STATE OF WASHINGTON
DEPARTMENT OF ECOLOGY

Re: SP-07-00007

Thank you for the opportunity to comment on the short subdivision of approximately 10.45 acres into 3 lots, proposed by Mark and Darcy Wenger. We have reviewed the application and have the following comments.

WENGER SHORT PLAT
KITTITAS COUNTY SHORT PLAT NO. 07-XX
PORTION OF THE NE 1/4, SEC.29 T.20N., R.14E., W.M.
KITTITAS COUNTY, WASHINGTON

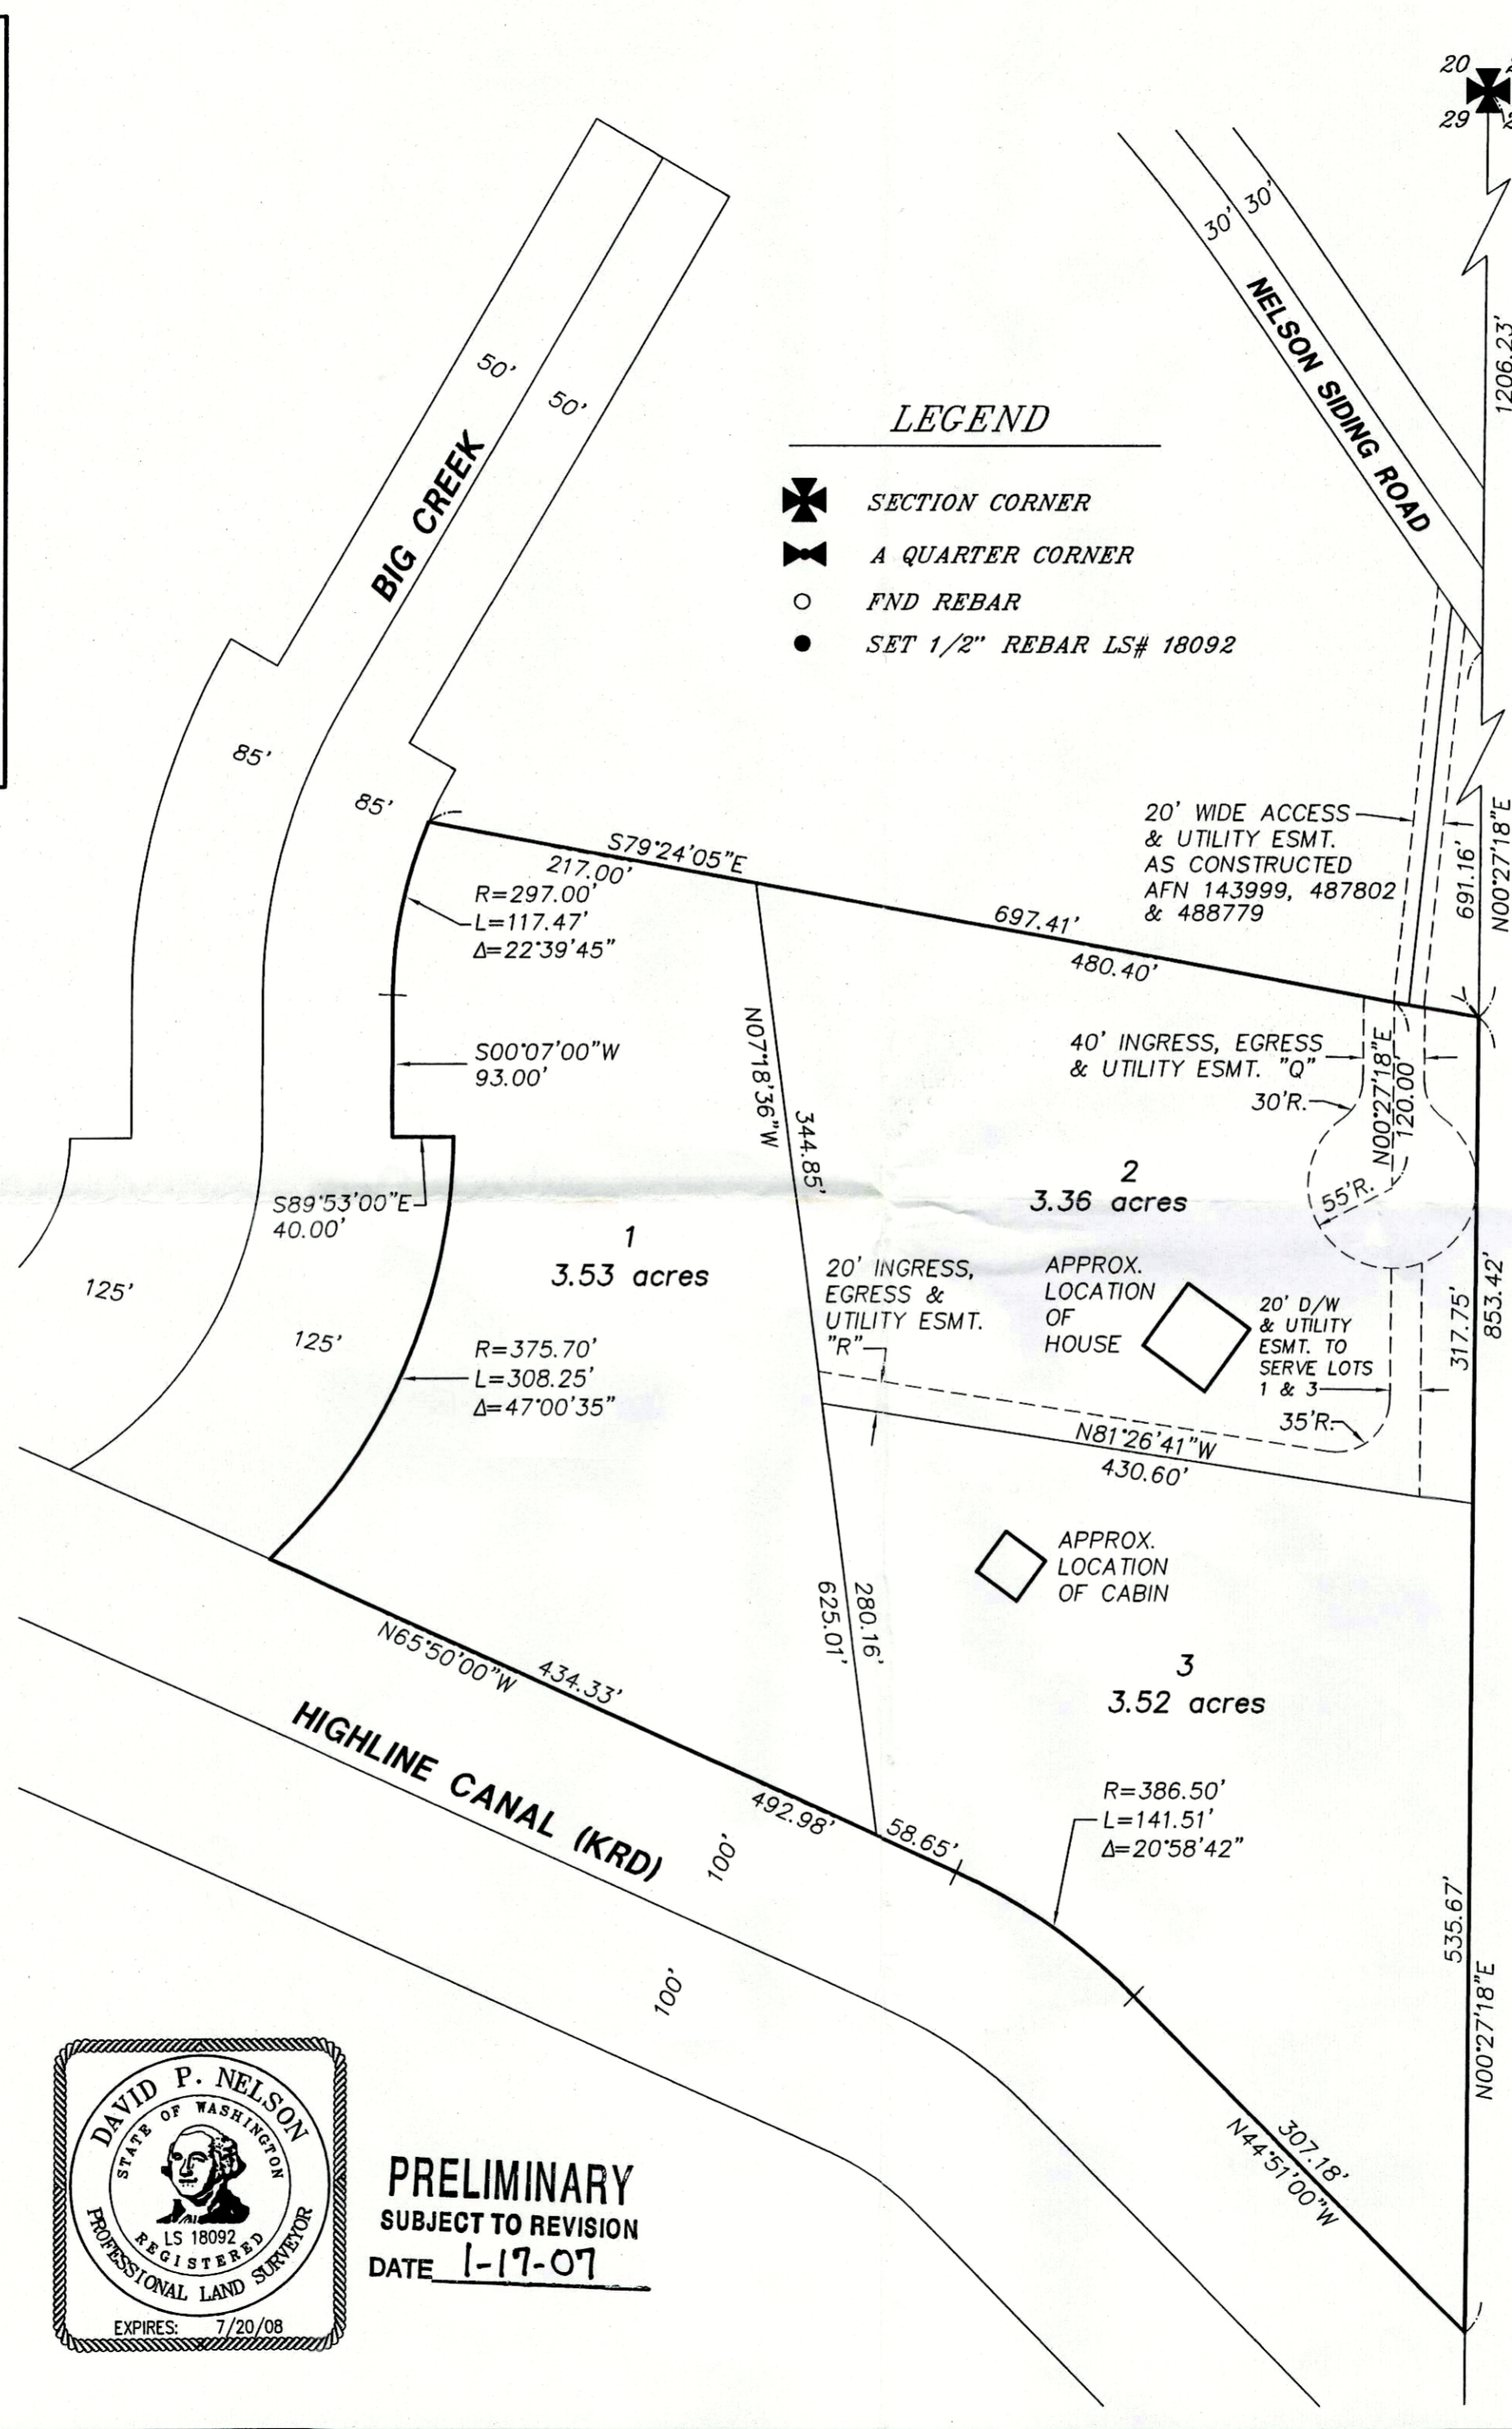
Ecology GIS aerial photo interpretation show areas on this parcel where wetlands may exist. A potential wetland area is within the currently proposed lot 1. Area water well reports show that static groundwater table levels are very close to the surface in the general area. An experienced wetland delineator should review the parcel for the presence of wetlands and complete wetland delineation and rating reports, if needed, before the lot configuration is approved. The parcel should be reviewed for the presence of wetlands to assure that all lots proposed have buildable areas and access to them that do not intrude on wetland buffers. Wetlands are particularly important for stormwater and flood retention along the Big Creek drainage, as floods have repeated occurred along this waterway.

Ecology would be happy to assist the County with a wetland reconnaissance to determine whether a wetland delineation and rating needs to be completed for the parcel. Please contact Catherine Reed at (509) 575-2616 for assistance.
